Application Ref:	3/2021/0130	 Ribble Valley Borough Council <small>www.ribblevalley.gov.uk</small>
Date Inspected:	15/02/21	
Officer:	RB	
DELEGATED ITEM FILE REPORT:		REFUSAL

Development Description:	Application for regularisation of the erection of a 1.8m high garden fence to the boundary and new parking area to the rear of the dwelling.
Site Address/Location:	67 Hillcrest, Langho, BB6 8EN

Proposed fence at :	
<b>67 Hillcrest Road Langho BB6 8EN</b>	
CLIENT:	Mr D Houlker
DATE:	December 2020
SCALE:	1:50 @ A1
DWG No:	Fence Elevations
L.A:	
AMENDMENTS:	DATE:
<b>ENTWISTLE DESIGN SERVICES</b>

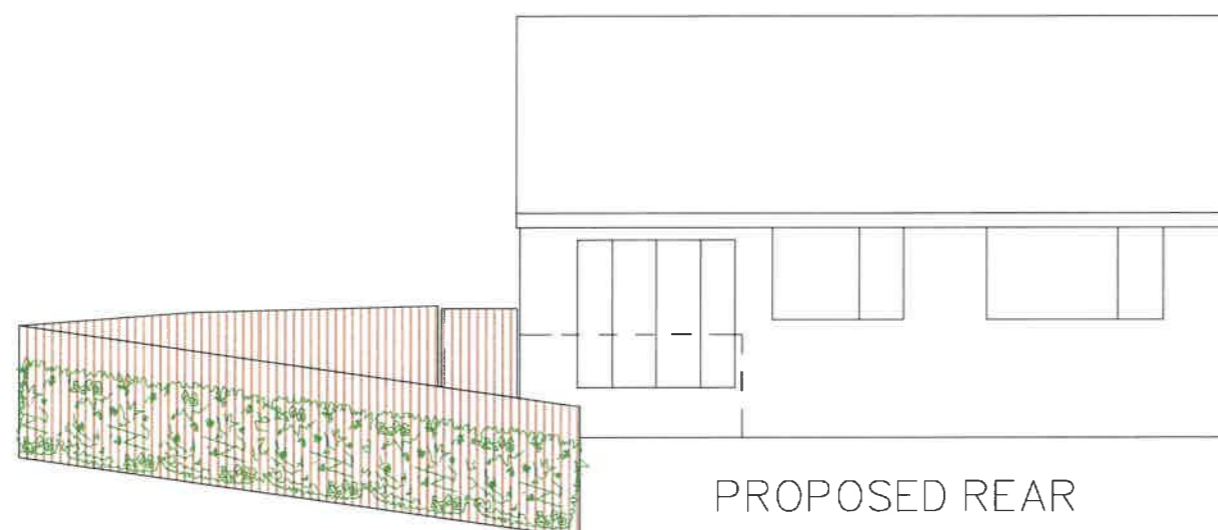
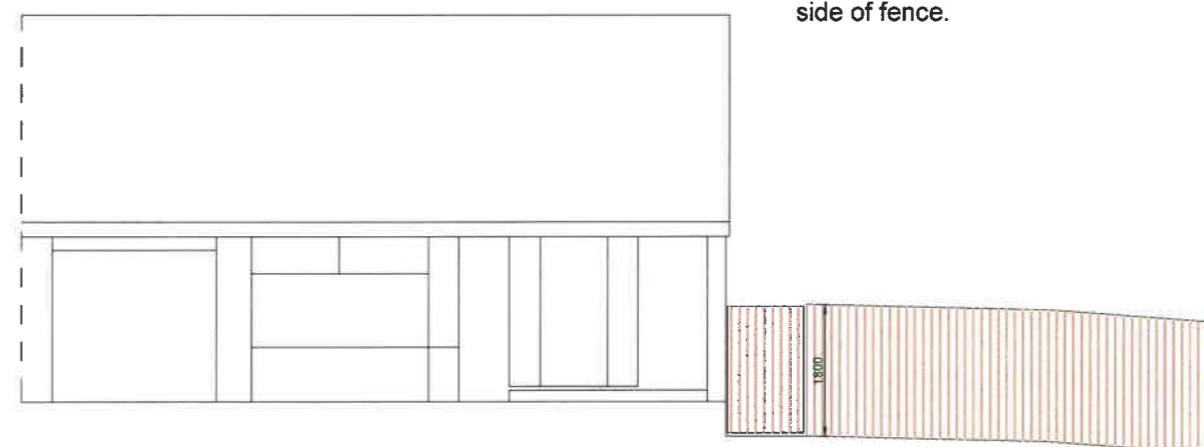
The retrospective application has removed a section of hedging at the site that will be re planted and the remainder of the hedge has been retained. Behind the hedge a 1.8m tall timber boarded fence has been erected. As built, the fence does appear to be taller than the fence that was previously situated on site. As the fence is of a solid construction despite being partially screened by the hedging the fence is visually dominant and is considered to be out of character with the wider area when compared with the existing boundary treatments in the immediate locality as mentioned above.

As such it is considered that the fence, by virtue of its size, scale and visual prominence, has resulted in the introduction of an incongruous feature within the streetscene that is visually dominant and harmful to the character and appearance wider area.
